**Locomotive Workshop (Bays 1 - 4a) (SSD-8517-Mod-5)
Request for Additional Information**

I refer to the modification application for the Locomotive Workshop (Bays 1 - 4a) (SSD-8517-Mod-5) seeking amendments to conditions of consent relating to staged Occupation Certificates and replacement of heritage glass panels.

C_STAGINGPLAN_4
CIVIL WORKS STAGING PLAN
DATE: 21/01/20
REVISION: 4

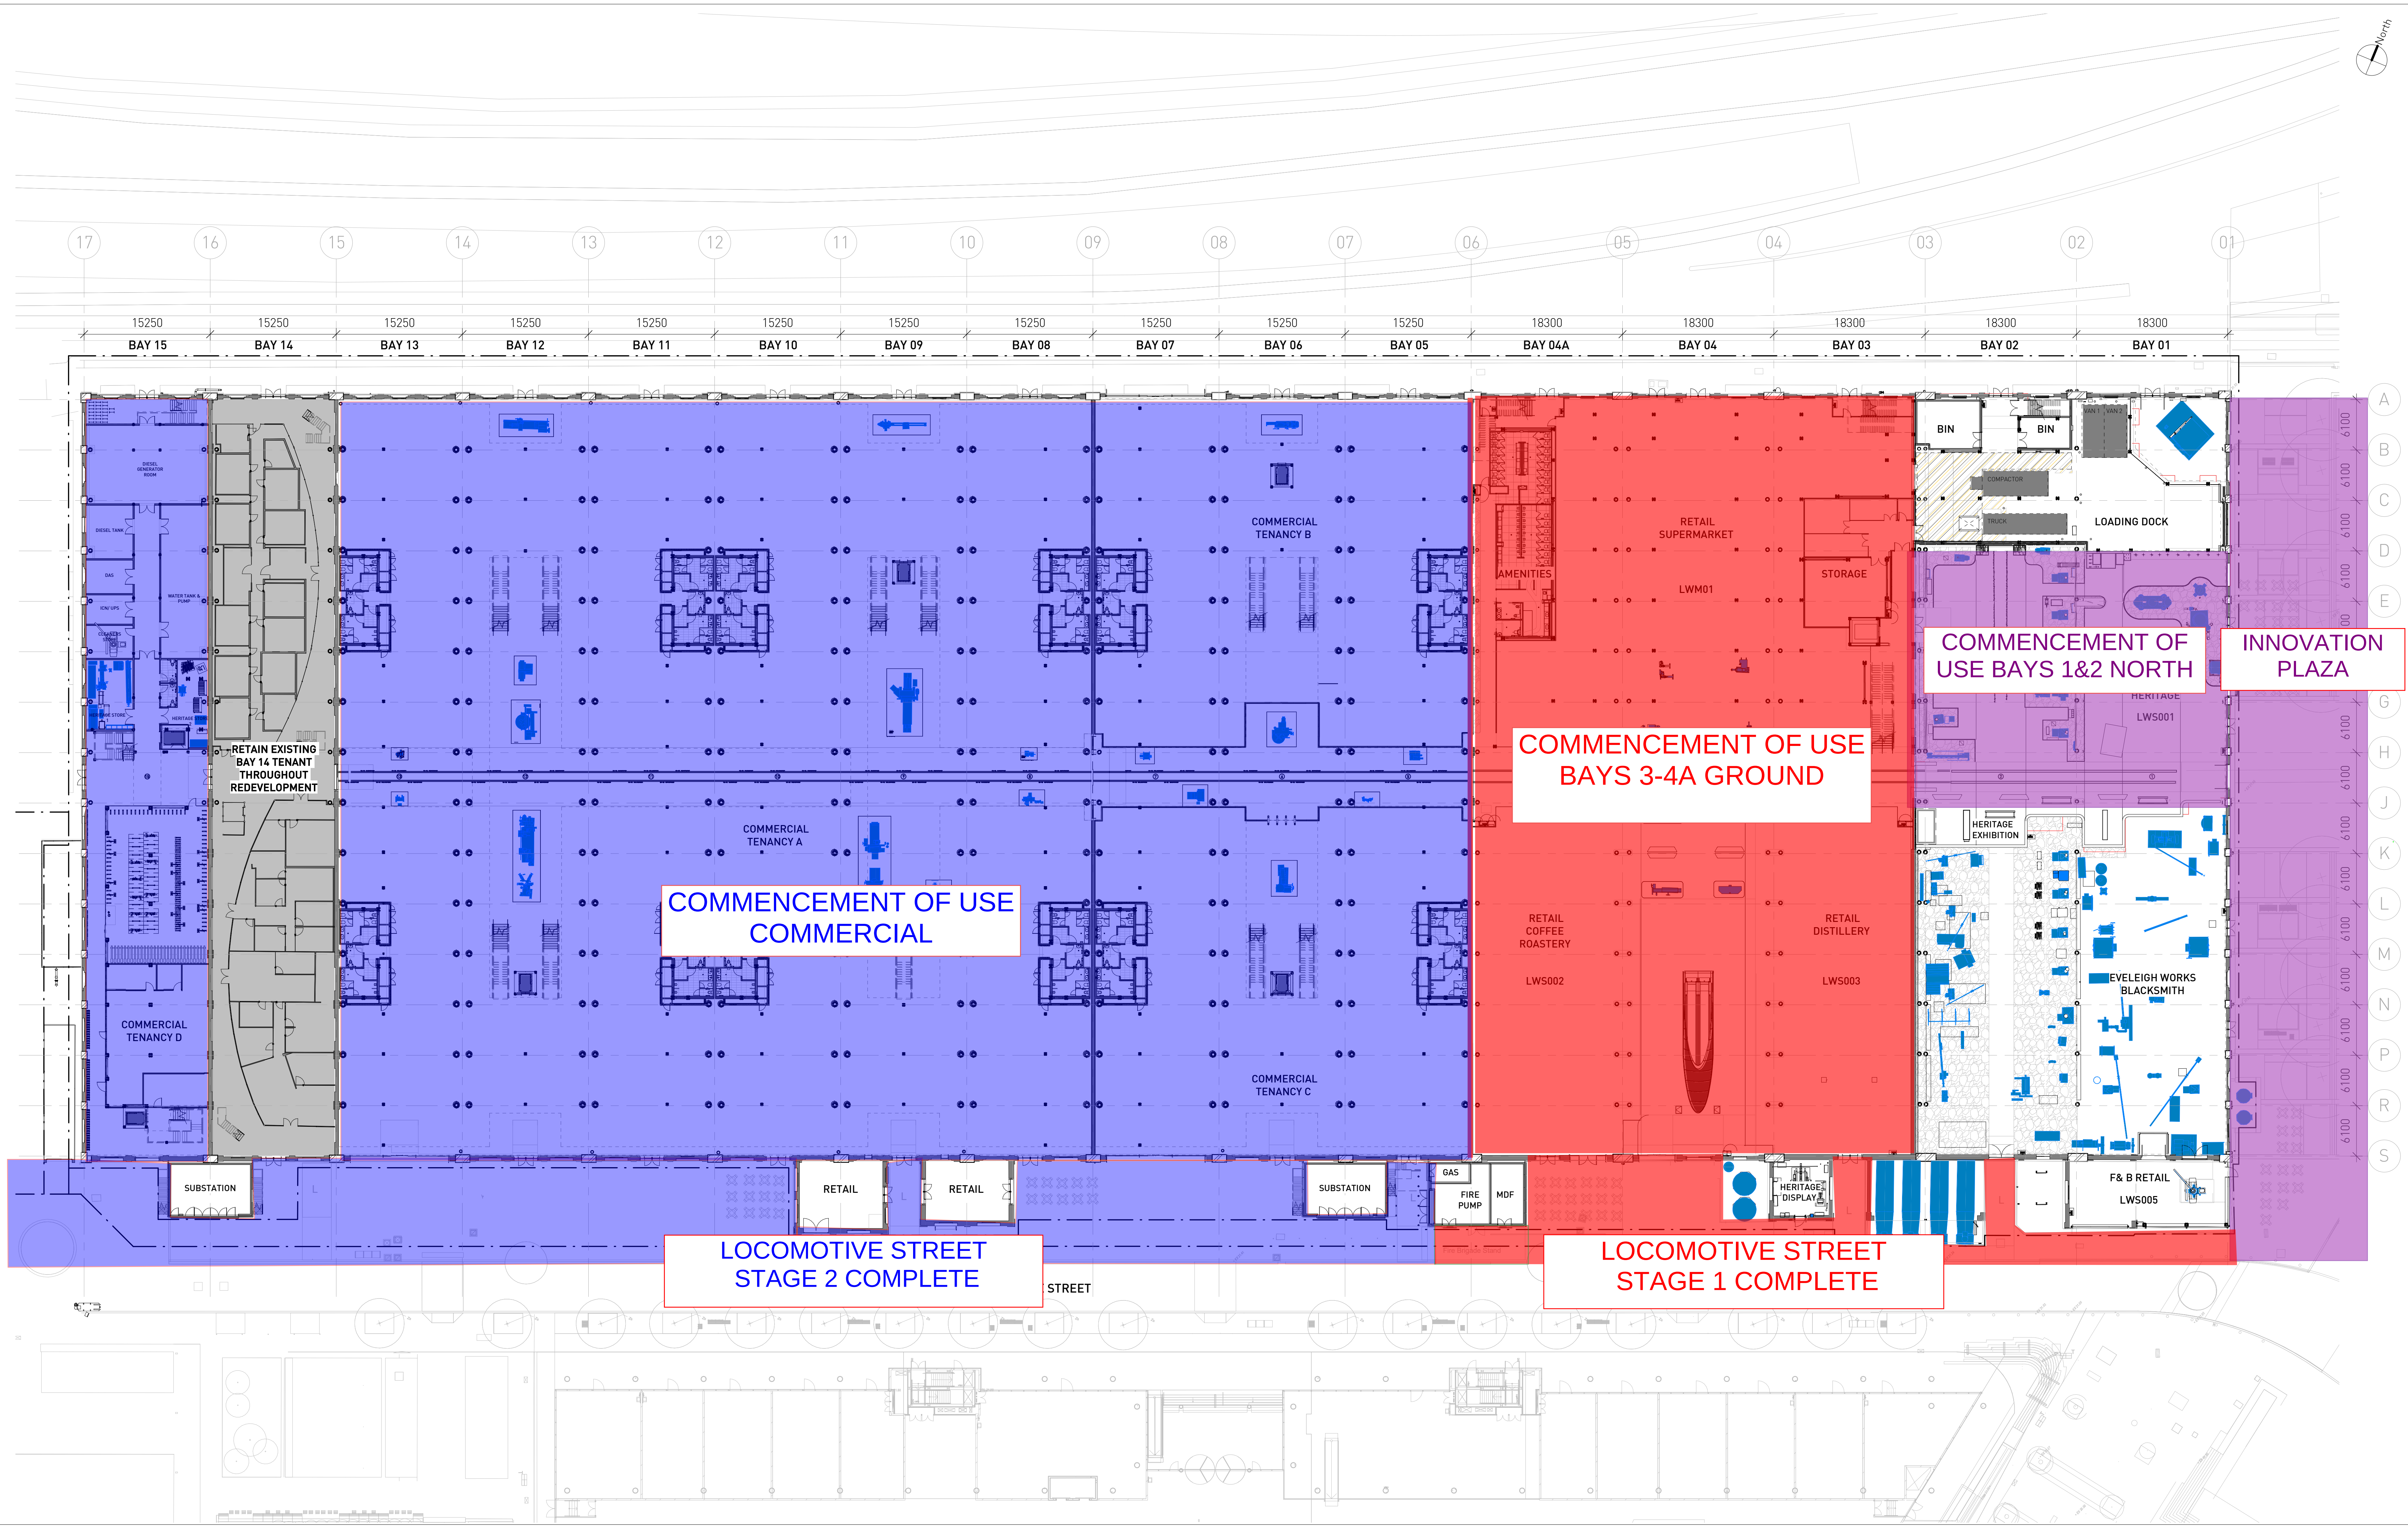
The proposed change to Condition E9 is inconsistent with the indicative staging plan provided, which shows:

- Innovation Plaza and Locomotive Street Stage 1 public domain complete October 2020
- Locomotive Street Stage 2 public domain complete March 2021
- Locomotive Street stage 3 public domain complete April 2021.

Please reconsider the wording of the proposed changes to Condition E9 to ensure the public domain is delivered consistent with the above staging.
